WEST SUSSEX COUNTY COUNCIL CONSULTATION

TO:	Arun District Council FAO:Simon Davis
FROM:	WSCC - Highways Authority
DATE:	13 October 2020
LOCATION:	Street Buildings North End Road Yapton BN18 0DT
SUBJECT:	Y/95/20/DOC Approval of details reserved by condition imposed under ref Y/13/18/PL relating to Condition Nos 16 - refuse & recycling bins and 19 - parking.
DATE OF SITE VISIT:	n/a
RECOMMENDATION:	Advice
S106 CONTRIBUTION TOTAL:	n/a

Title:
PARKING AND CYCLE STORAGE PLAN

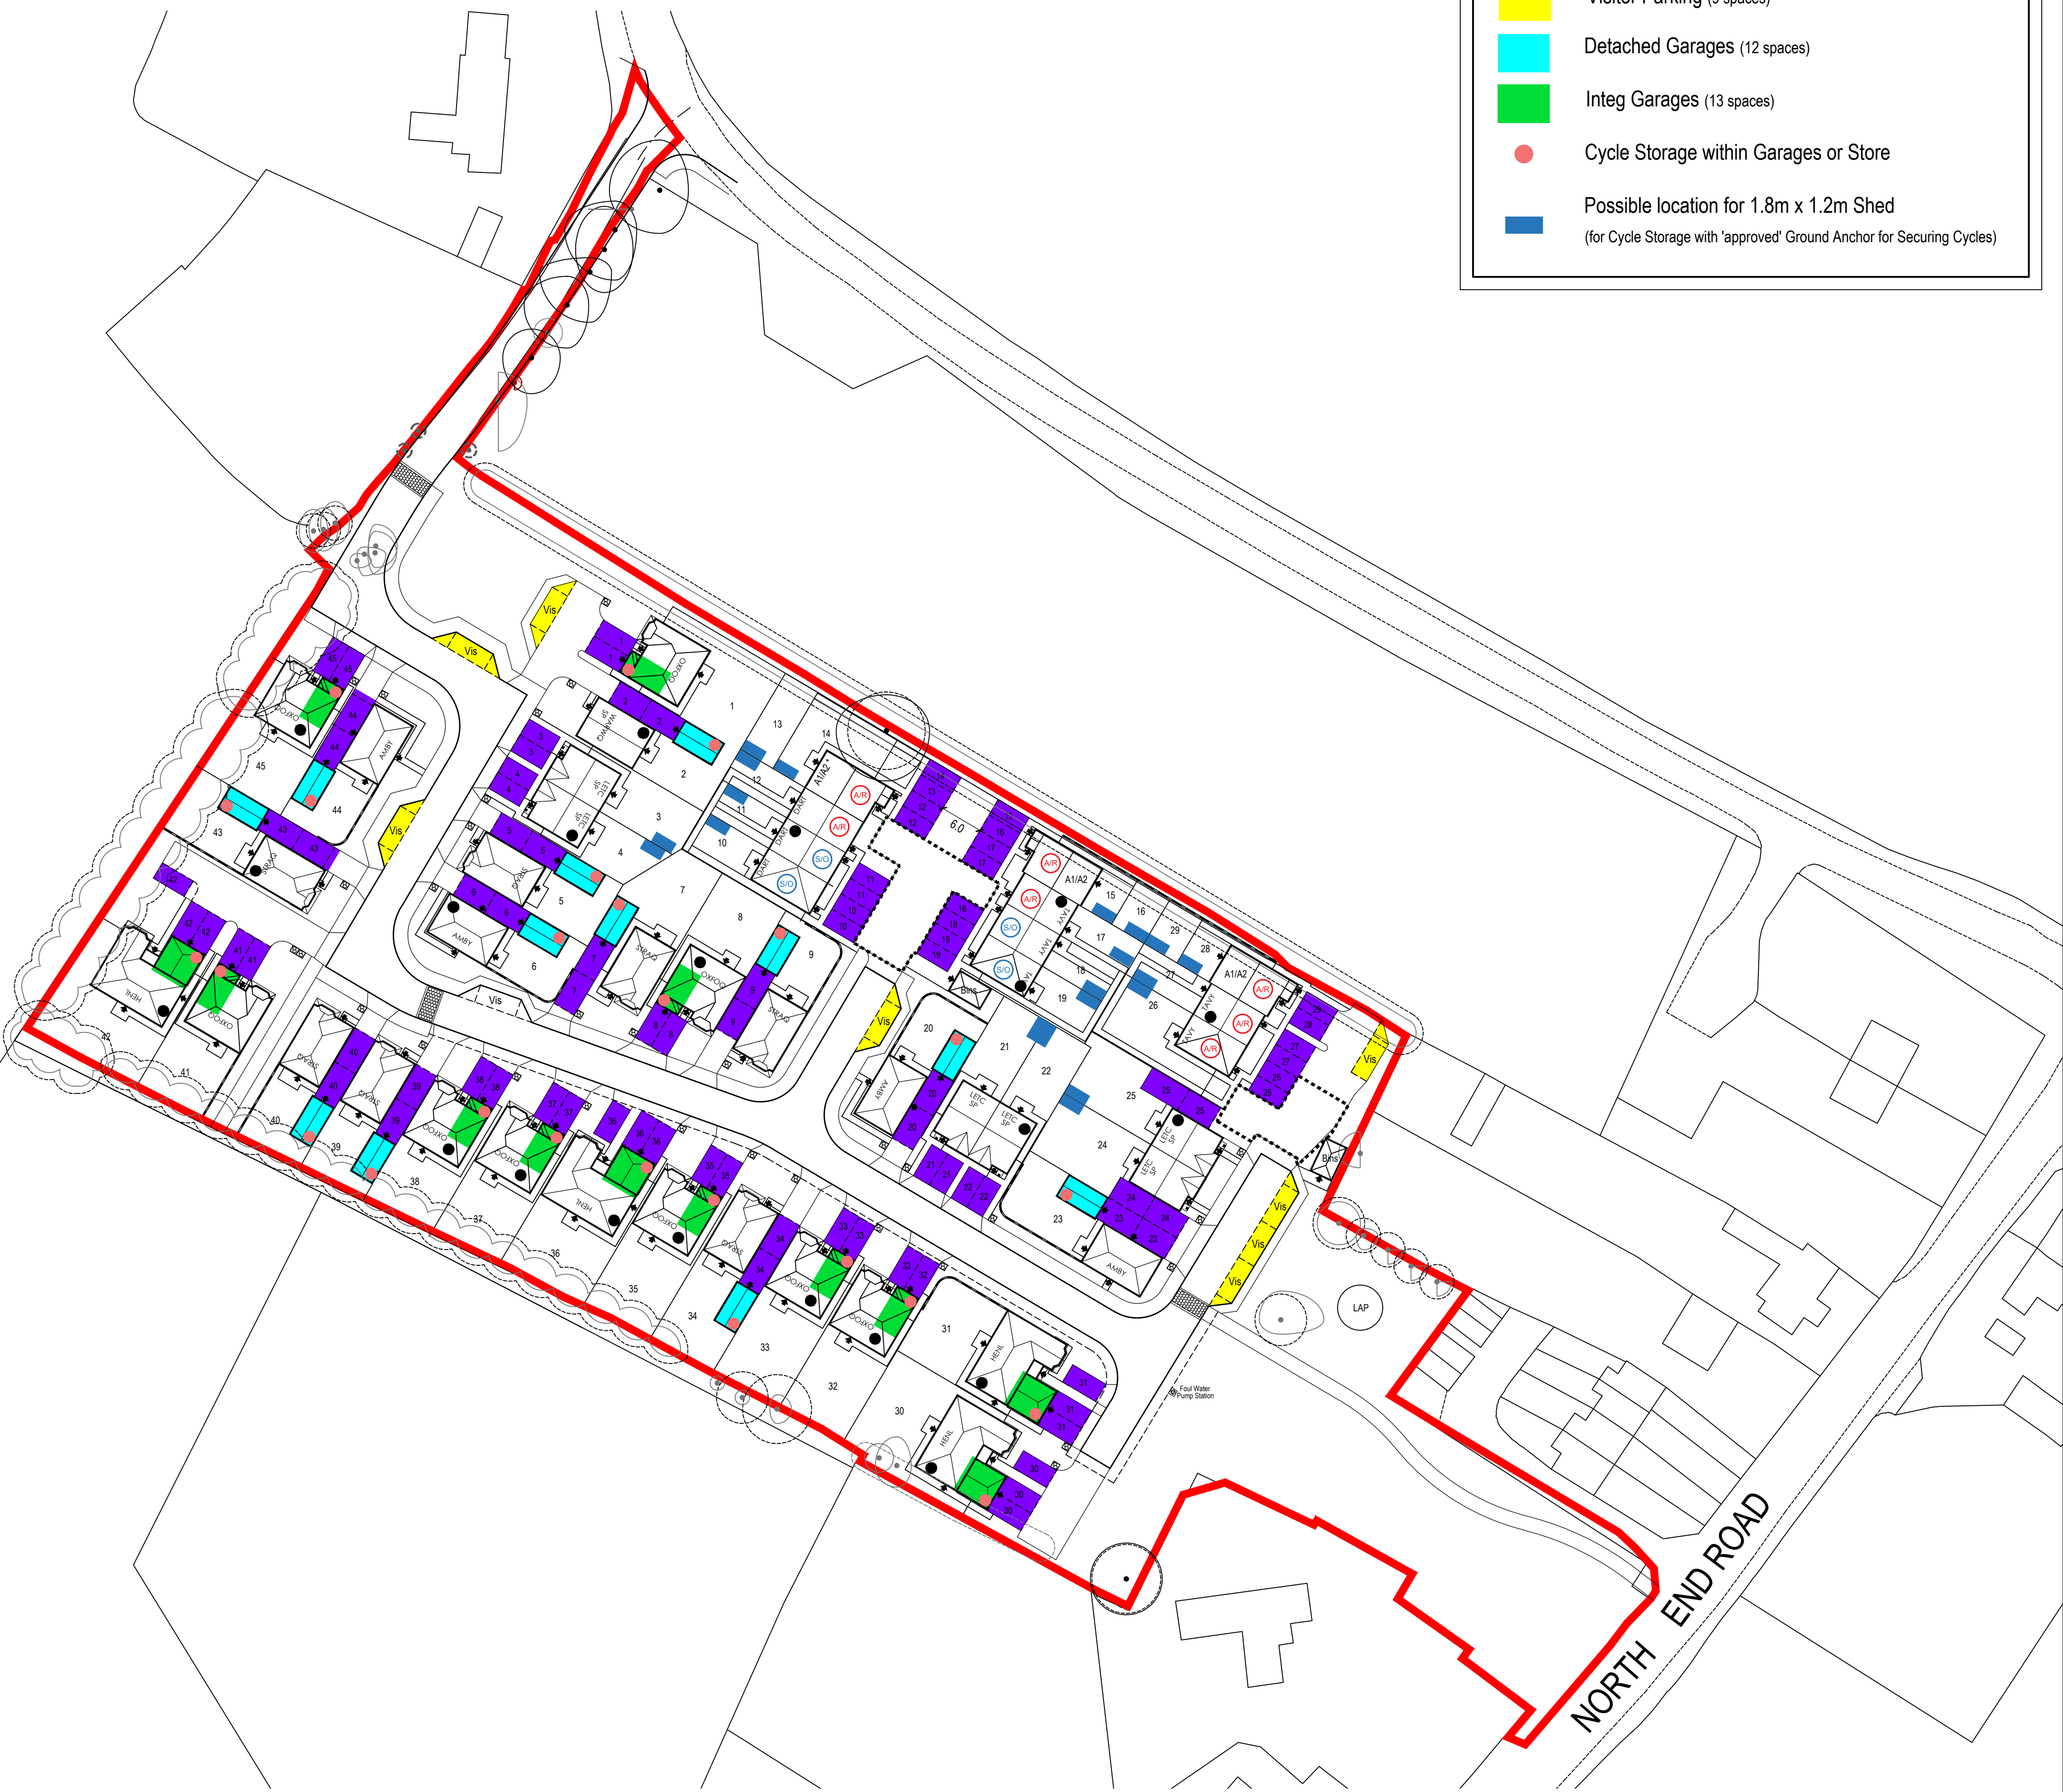
Condition 19- Parking has been demonstrated on drawing 072 which includes cycle spaces in storage areas. The LHA is satisfied with the parking levels provided including the outlined visitor spaces on the estate road. On the basis of the above and information submitted the LHA would be satisfied this condition can also be discharged.

Drawing Title
**REFUSE VEHICLE
SWEEP PATH ANALYSIS**

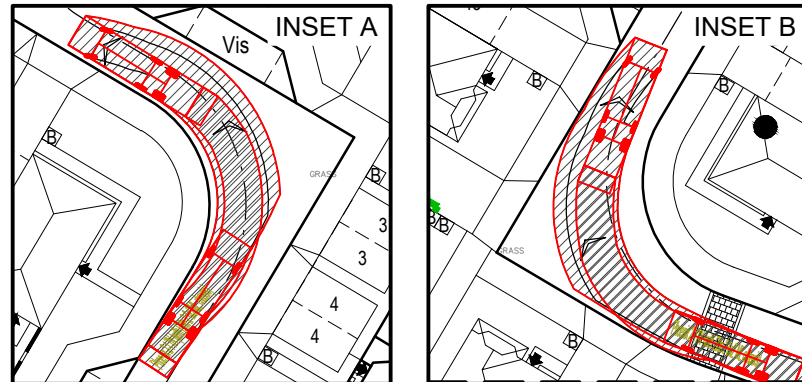
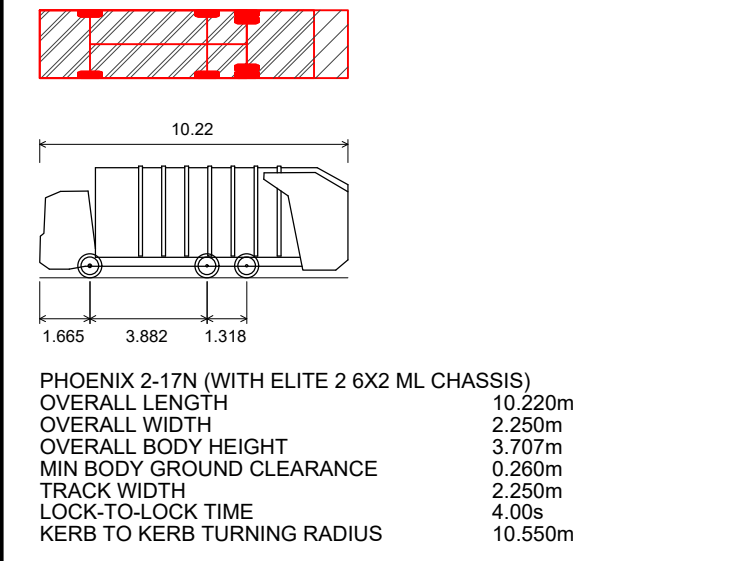
Condition 16- Swept Path Diagrams have been demonstrated on drawing 18-343-100 Rev C. This demonstrates a refuse tender can turn within the site access roads. The LHA are satisfied that this condition can be discharged.
